SUBJECT: Engineering Review Comment  
Mountain View Electric Association Inc. (MVEA)

**Project Name: Preamble at Hannah Ridge Filing 3 – Final Plat**

**Project Number: SF251**

**Description:** A proposed development of 38 residential lots and 4 tracts located west of Marksheffel Rd. and north of Constitution Ave. in Township 13S, Range 65W, Section 32.

PREAMBLE AT HANNAH  
RIDGE FILING NO. 3  
JOB NO. 1116.35  
NOVEMBER 29, 2024  
SHEET 2 OF 4

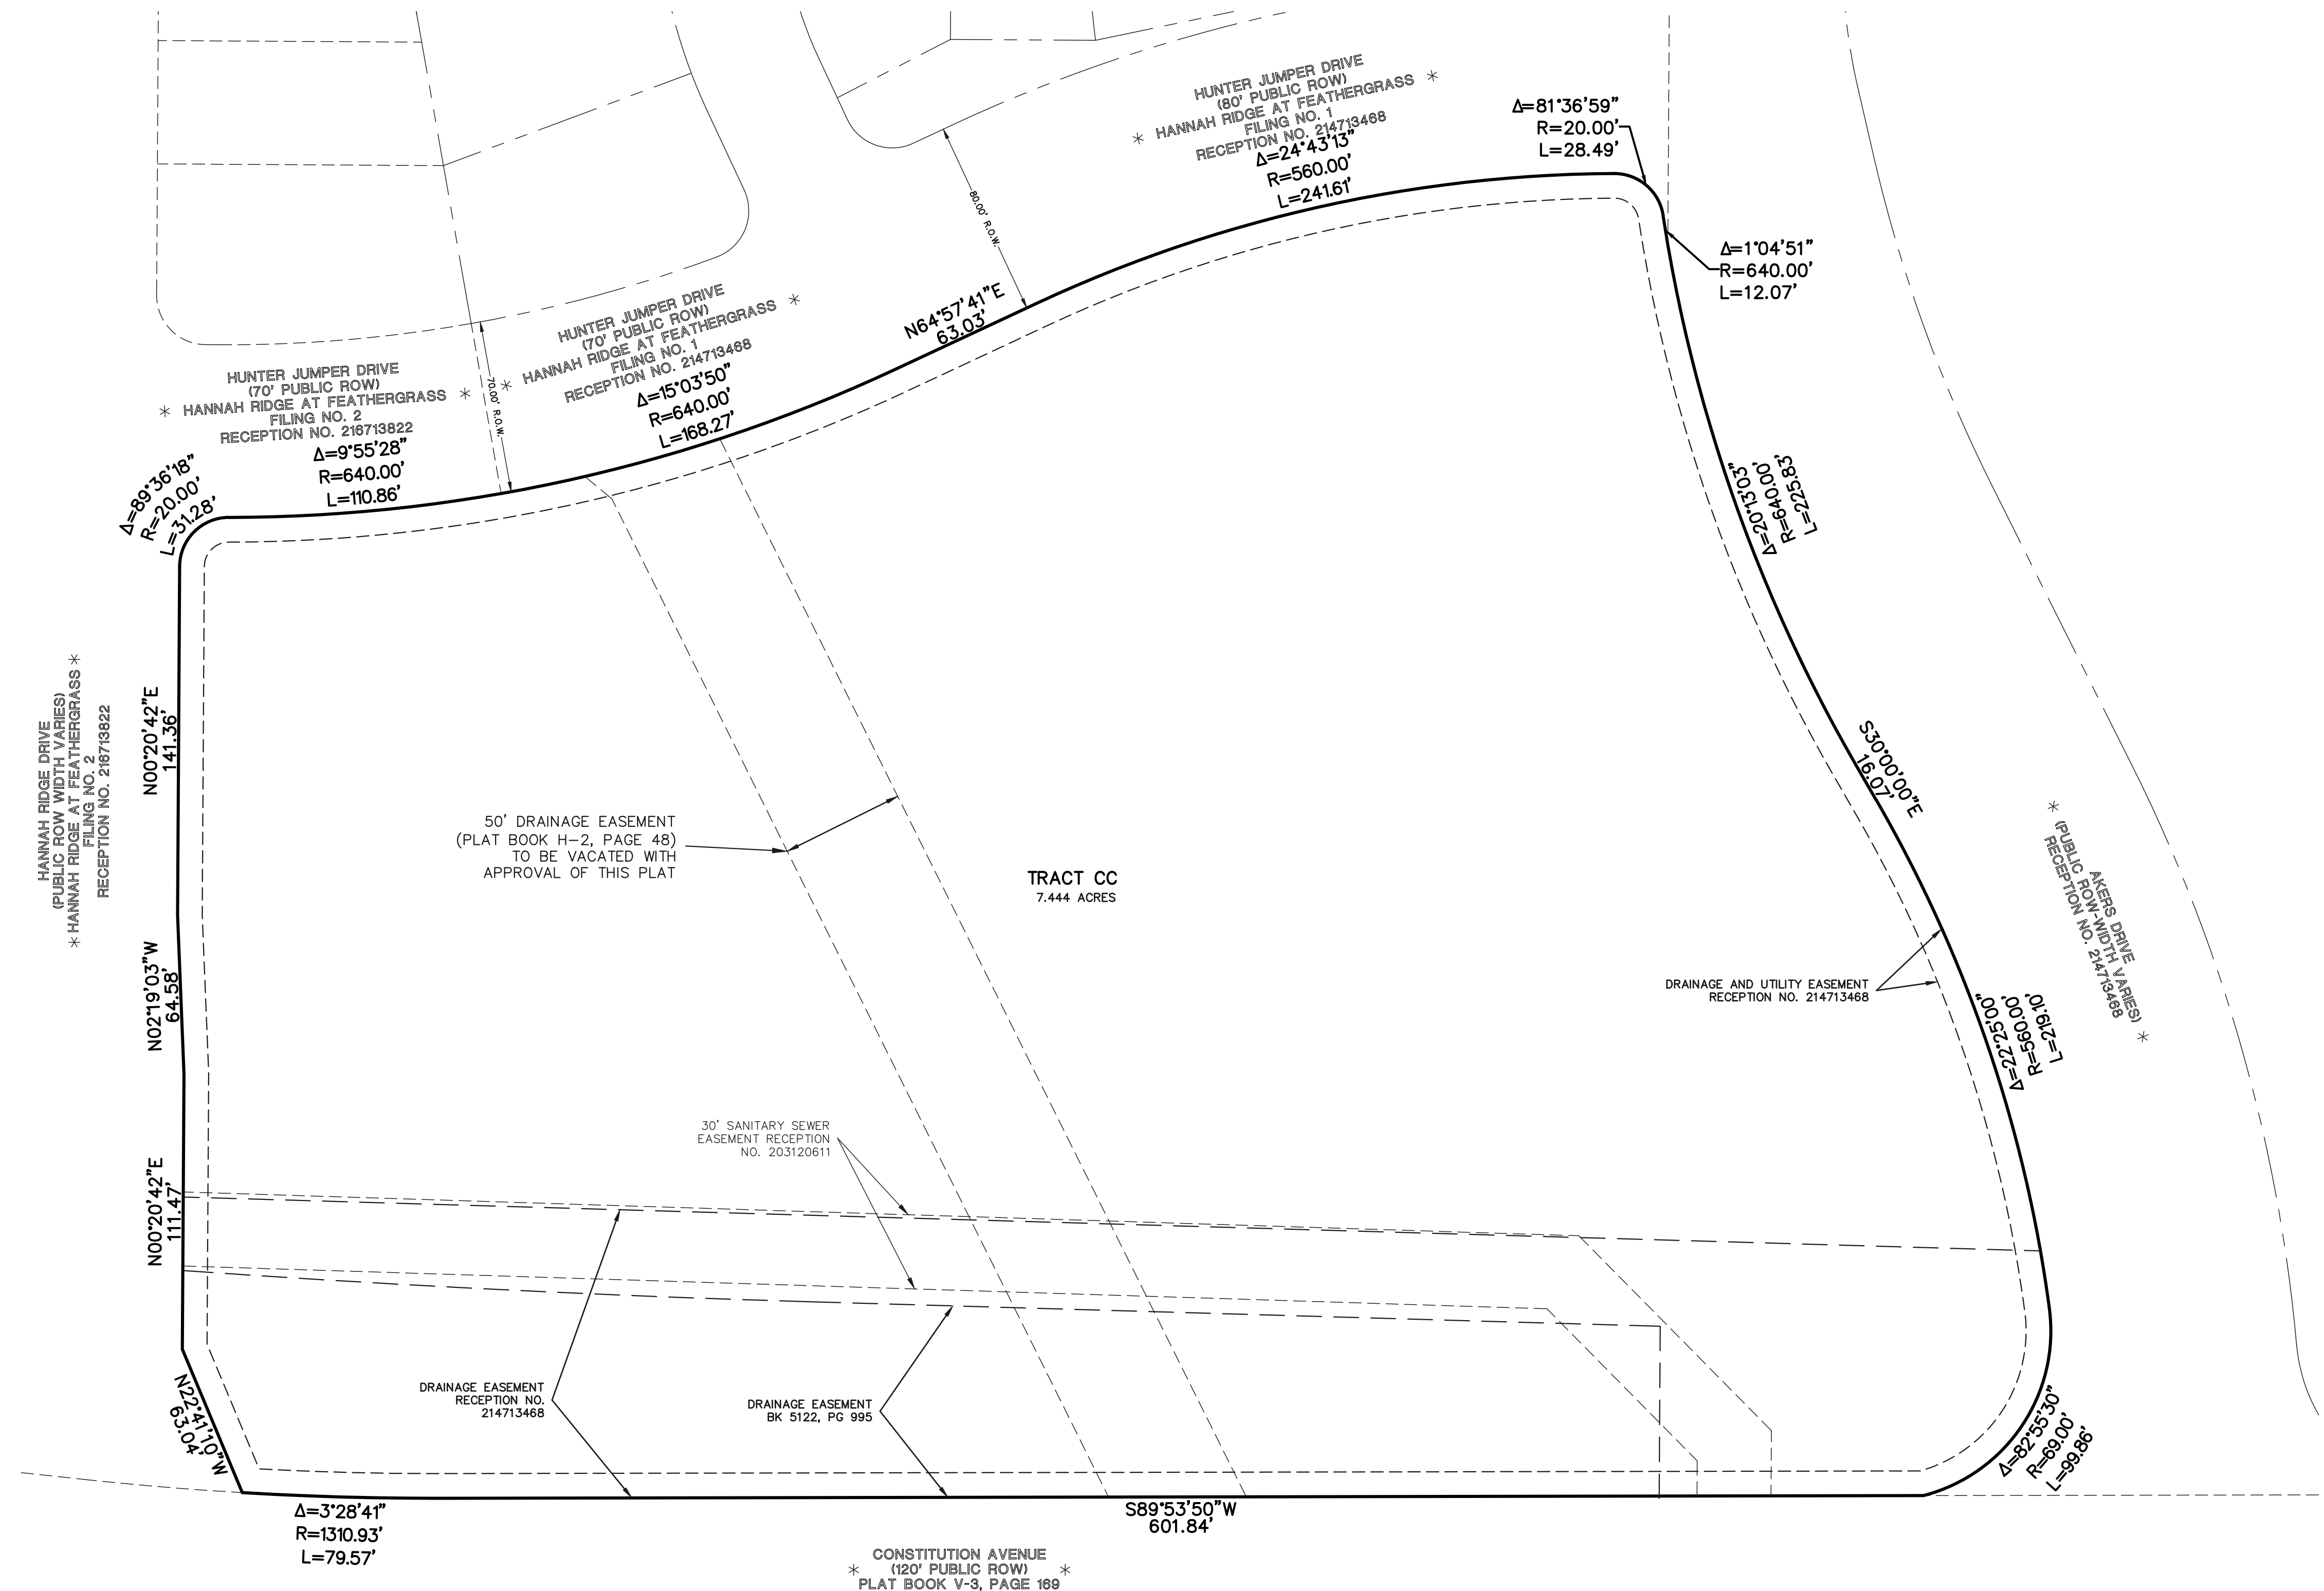
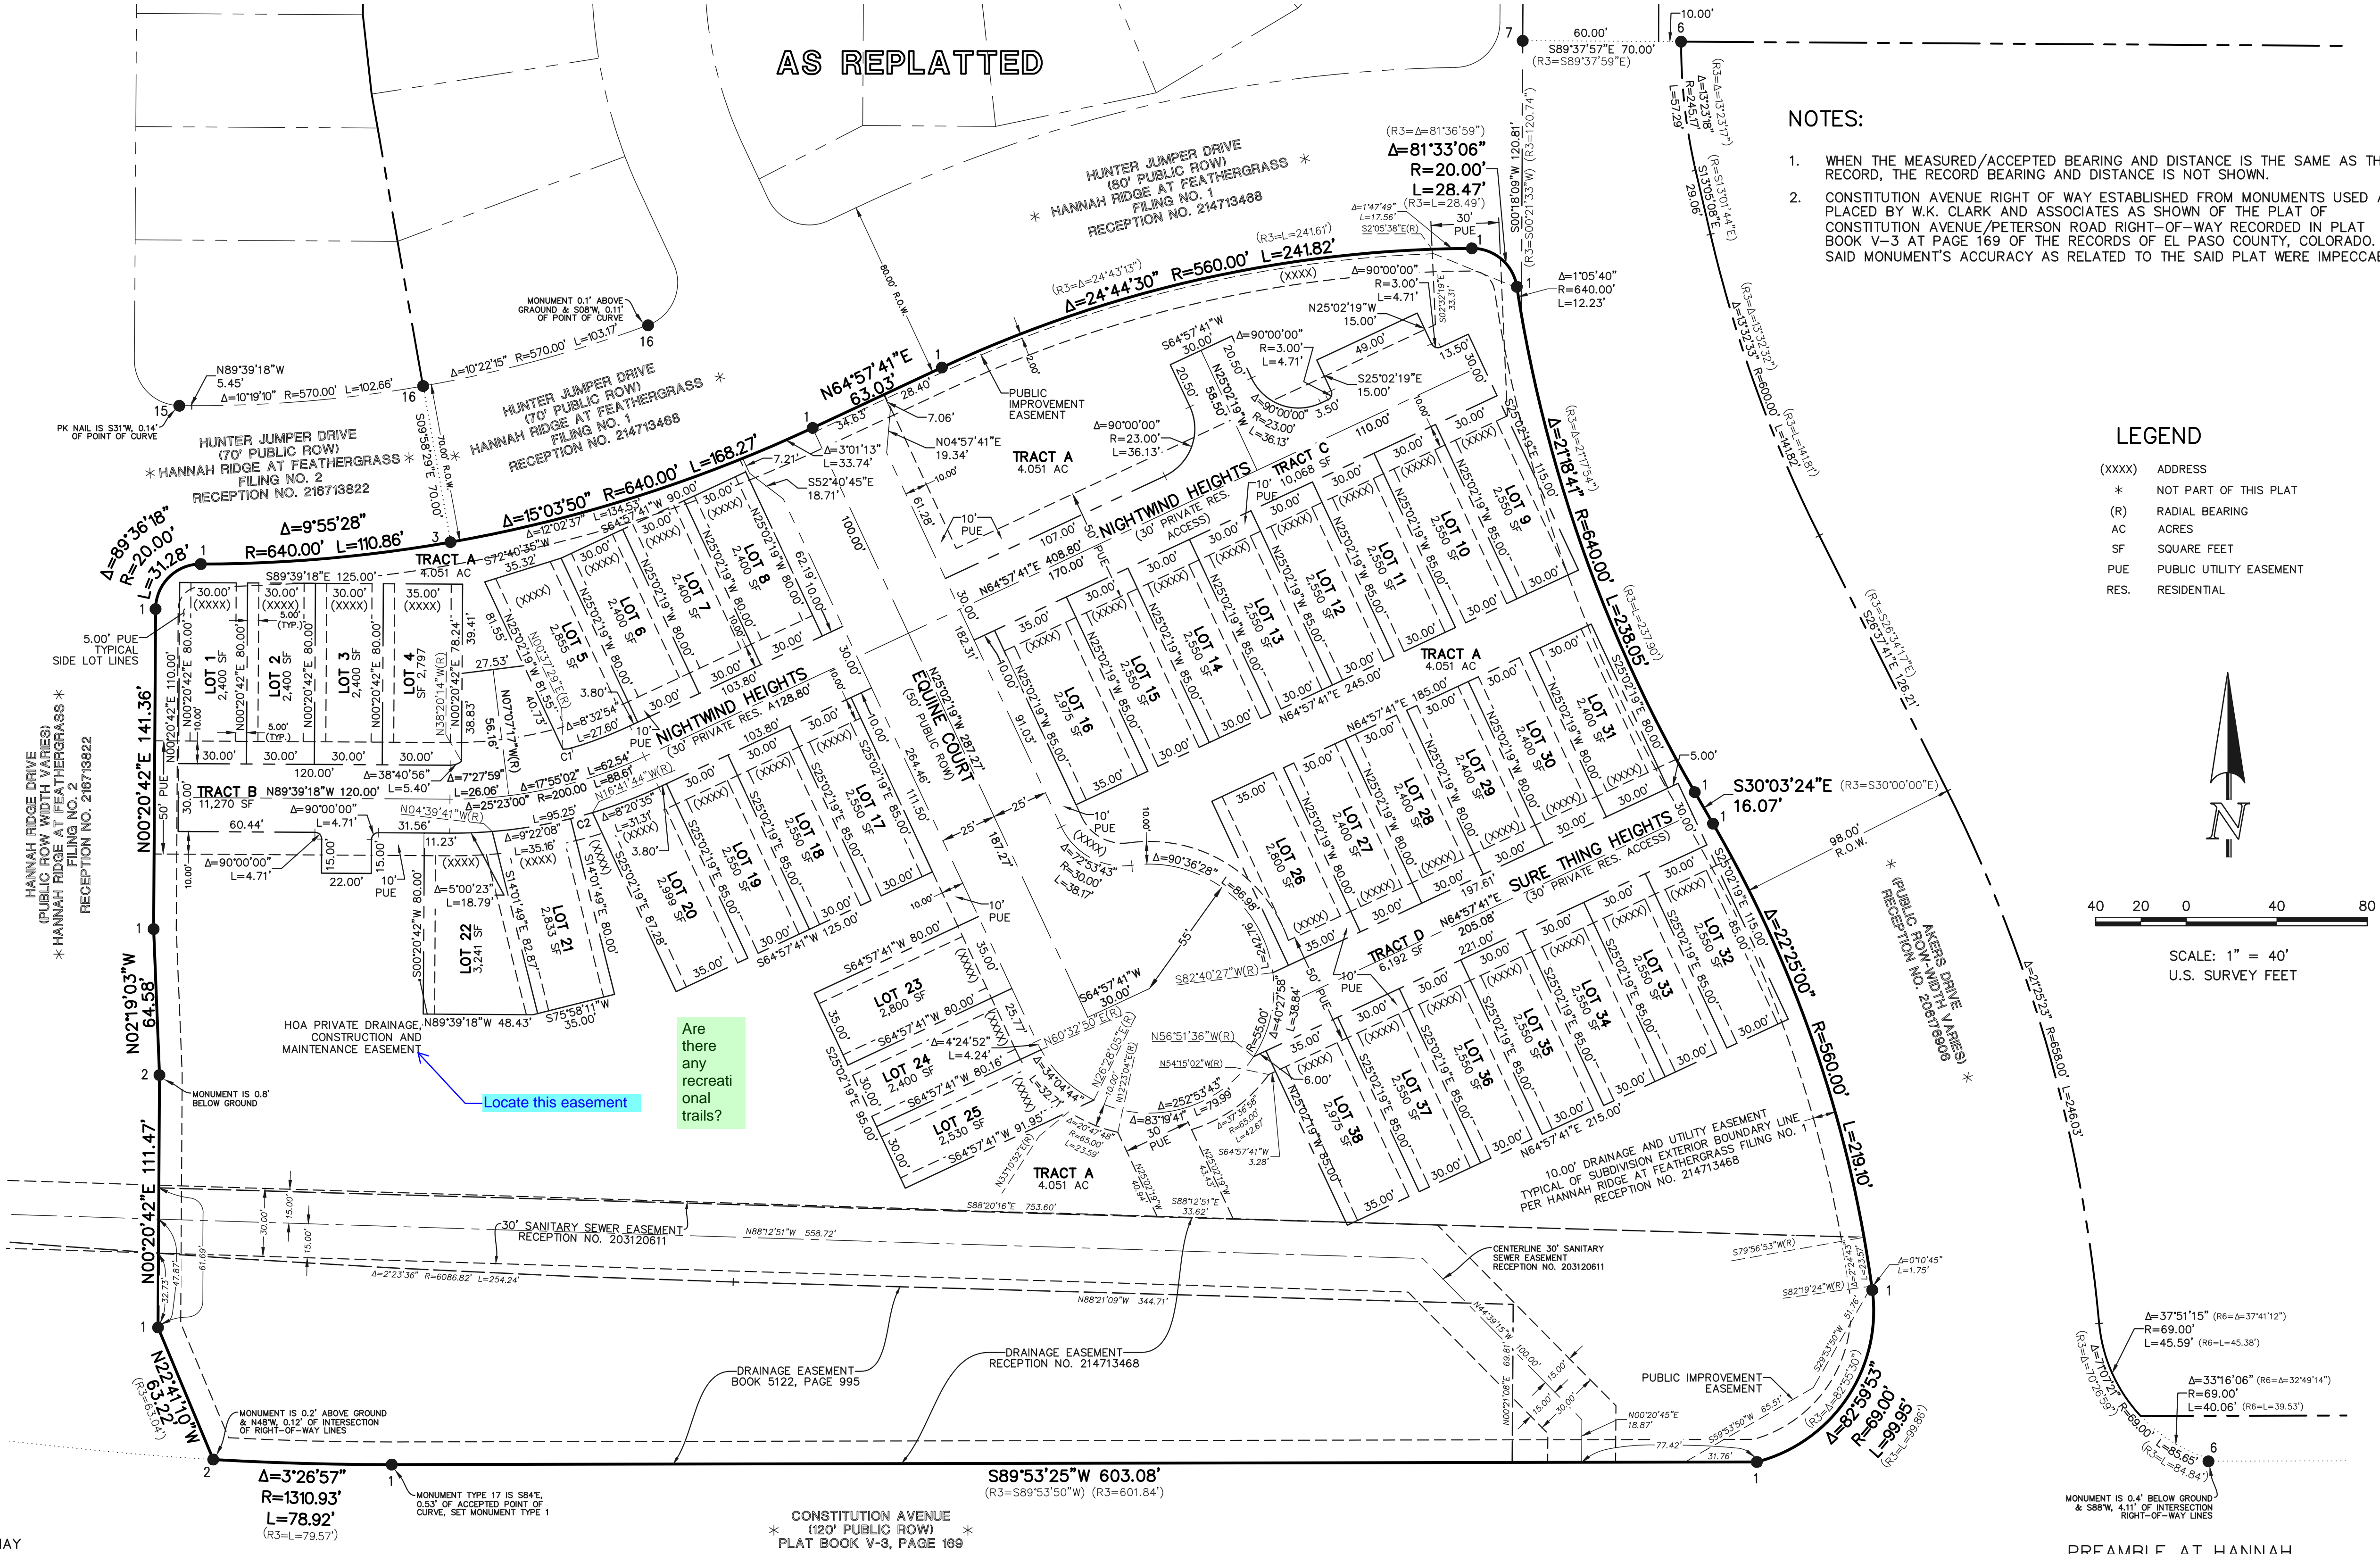
MVEA requests a ten (10) foot front lot line utility easement, all open spaces and tracts will be defined as a public utility easement, and a twenty (20) foot exterior boundary utility easement on the plat and all tracts. MVEA will work with the developer on the electric line design. MVEA also requests the platting of MVEA's existing facilities with easements on the plat. Additional easements may be required.
